RE: 1341 Flightway Ave. SE
Grading and Drainage Plan
Engineer's Stamp Date: 08/07/23
Hydrology File: M15D023A

Based upon the information provided in your submittal received 09/13/2023, the Grading & Drainage Plan **is not** approved for Building Permit and Grading Permit. The following comments need to be addressed for approval of the above referenced project:

SHEET NO:  
C - 1

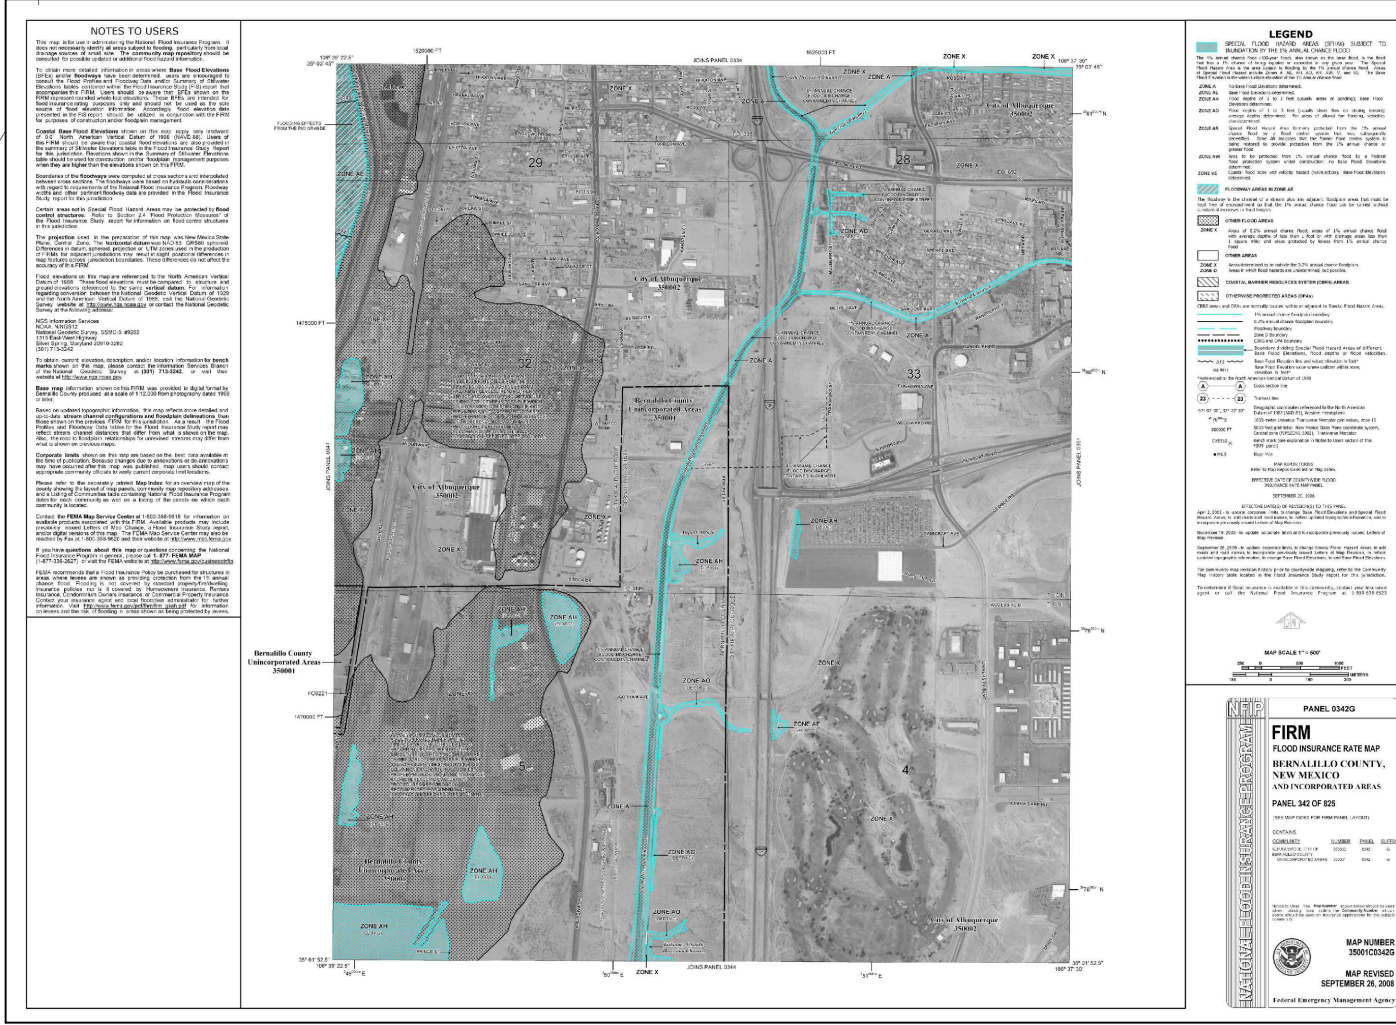
1. Per the DPM, the following must be on the Grading Plan. Please note the Grading Plan must be a stand-alone construction document.

- a. Please provide a Vicinity Map. Typically, this is the Zone Atlas. This can be downloaded in pdf format from the City of Albuquerque's website.
- b. Please provide the full FIRM Map and flood plain note with effective date.

2. Please use the procedure for 40 acre and smaller basins as outlined in Development Process Manual (DPM) Article 6-2(a). Please provide both the existing conditions and proposed conditions for the 100 year-6 hour storm event.
3. Please follow the DPM Article 6-12 Stormwater Quality and Low-Impact Development for the sizing calculations. To calculate the required SWQV, multiply the new impervious area (Square feet) draining to the BMP by 0.26 inches for redevelopment sites divided by 12 to get the required volume in cubic feet. The calculations of both the required and the provided volume of each BMP must be shown on the Grading and Drainage Plan. Each BMP should be labeled on the Grading and Drainage Plan with the required SWQV and associated water surface elevation and the 100-year water surface elevation.

4. Please include under the Existing Conditions, "This site is within the Sunport Park Phase 1 Master Drainage Plan. This site has an allowable discharge of 3.2 cfs to Flightway Ave."
